Office of
Environment
& Heritage

Our reference: DOC15/218430
Contact: Marnie Stewart, 9995 6868

I refer to your letter received by the Office of Environment and Heritage (OEH) on 10 June 2015 requesting comments on the Environmental Impact Statement (EIS) for the Sumatran Tiger Adventure, Taronga Zoo, during the public exhibition (SSD 6864).

2 **EXISTING AND DEMOLITION - LEVEL 2 PLAN**
1:250

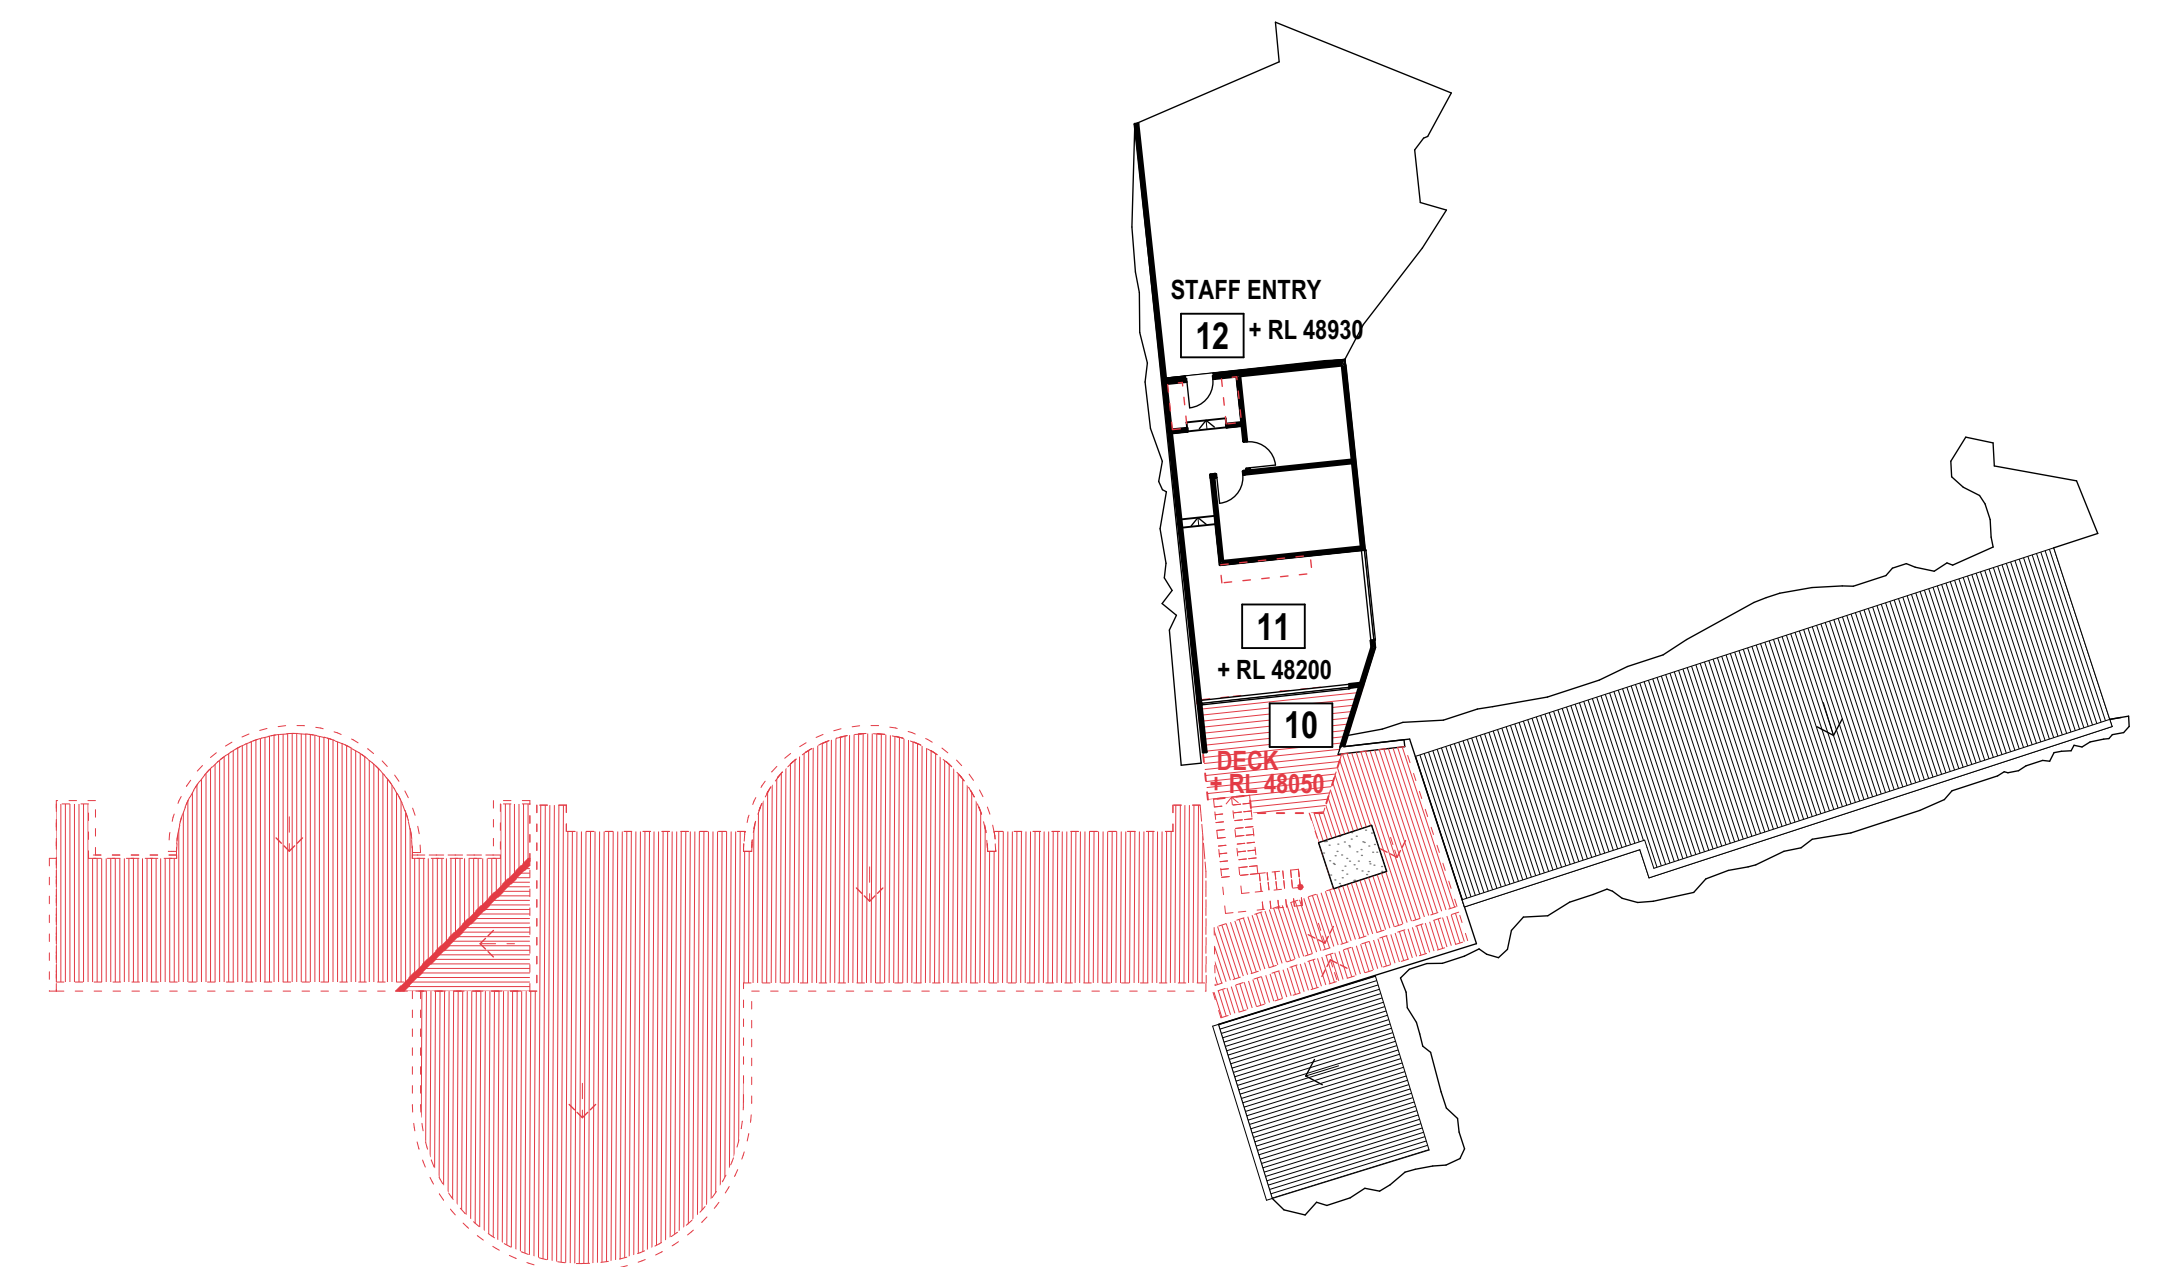
OEH has reviewed several relevant components supporting the EIS. OEH understands that the SSD activities which may cause harm to the AHIMS site include the removal of former animal shelters located immediately above the rock wall, to which the rock shelter is attached. It is proposed that the SSD will resolve outstanding stormwater and ground water management which will reduce the water movement over and through the rock shelter, thus reducing harm to the artwork and shelter by excess water activity. The SSD has also considered the movement of machinery and construction activities including demolition of existing structures as well as excavation. The management of loads in relation to the rock wall have also been incorporated into the SSD. In particular, this last component of SSD work will be monitored through vibration assessment. There are also proposed management works within the Construction Environmental Management Plan (CEMP). These elements are appropriate to ensure the ongoing protection and conservation of this significant Aboriginal cultural heritage site. OEH further notes that this site is the only currently known Aboriginal site within Taronga Zoo, although several others exist in land surrounding it.

The Aboriginal cultural heritage assessment report (ACHAR) which was provided in support of the SSD application has also been reviewed by OEH. The ACHAR has identified that once existing/former animal shelters and paths above site #45-6-1959 are removed this will stop water being directed over the edge of the rock face and into the Aboriginal site. This should assist in reducing water seepage through the rock and into the artwork, which has been steadily deteriorating since its first recording in 1990. However, OEH notes that the stormwater and wastewater plans supplied with the EIS do not appear to show how water will be captured and redirected to avoid this site. There is no discussion in the EIS as to whether additional water management other than removal of existing structures and paths is necessary and if so what is proposed. This is an important element which OEH recommends be resolved with the applicant prior to determining the application. Without this clarity, AHIMS site #45-6-1959 may continue to deteriorate from persistent water movement within the sandstone wall. This activity is likely to make the current deterioration worse and result in future collapse of the shelter and loss of its remaining artwork.

OEH understands that the application has addressed requirements of Aboriginal community consultation and the identification of areas of significant Aboriginal cultural heritage values in accordance with the SEARs. Considering the above advice, OEH recommends that DPE seek advice from the applicant as to whether additional water re-direction is necessary and required to address this existing issue and ensure the future protection of AHIMS site #45-6-1959. In the event that additional water re-direction is required, OEH recommends that these details should be clearly incorporated into the plans and EIS documentation and provided to DPE prior to determination of the SSD application. OEH advises that provided DPE is satisfied that the applicant has addressed the matter of water re-direction in relation to AHIMS site #45-6-1959, further referral to OEH on this matter is not required.
